From: Jean Fraser
To: angel.robinson@guggenheimpartners.com; dfenstermacher@vhb.com
Date: 2/16/2016 2:38 PM
Subject: Re: Taco Bell at 1363 Washington Avenue
Attachments: 2016.02.15 Washington Ave Peer Review Memo.pdf

I attach the comments of the Peer Engineer Reviewer from Woodard & Curran (they focus on site stormwater and utilities). I would be grateful if you could also address or respond to these comments.

*Jean Fraser, Planner
City of Portland
874 8728*

Drawing Title
Planting Plan

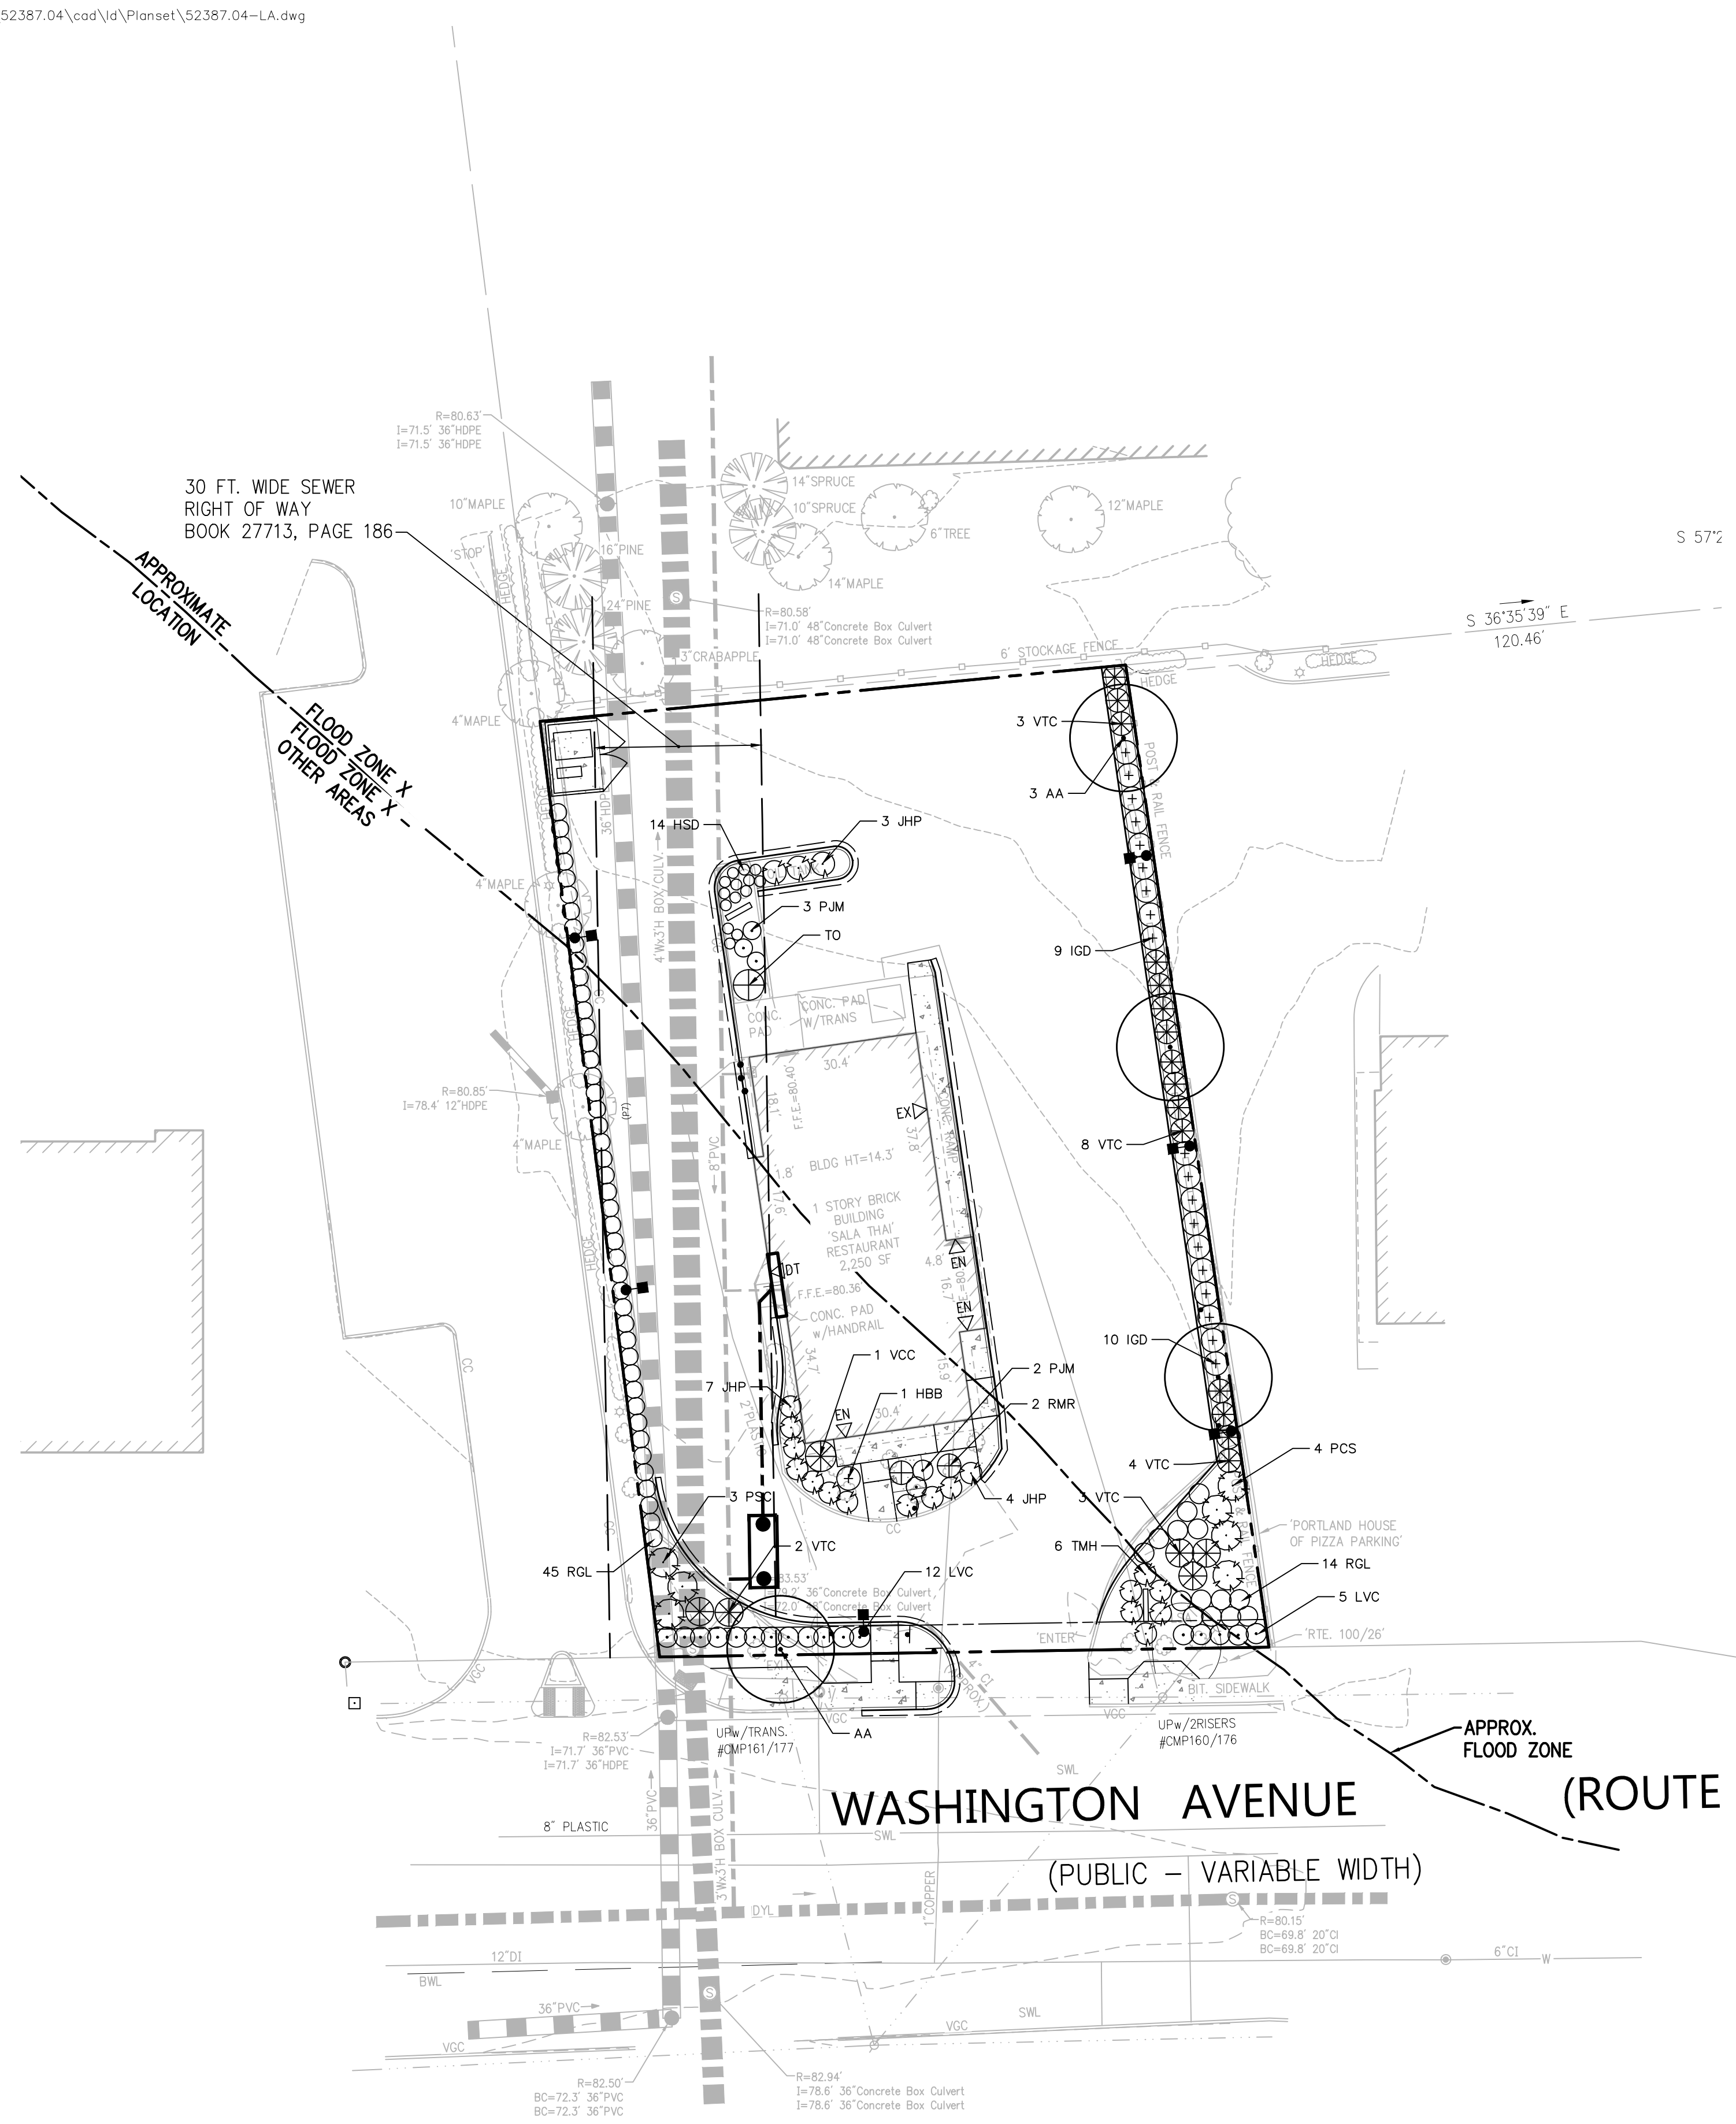
Landscaping and B2 Design Standards re screening: the entire site is subject to landscape and screening standards and there are also street tree requirements - please see 14-526 (b)2 b *Environmental Quality Standards* (attached) and the *B2 Design Standards* para 8 (attached). There is also guidance in the City's Technical Manual (Section 4) which is on the Website at <http://www.portlandmaine.gov/documentcenter/view/2211> The City Arborist will be reviewing the plan and may suggest specific improvements, but I think this might need to wait until the access question is resolved. In any case the dumpster would need to be enclosed and parking lot landscaping be enhanced; snow storage areas should be identified.
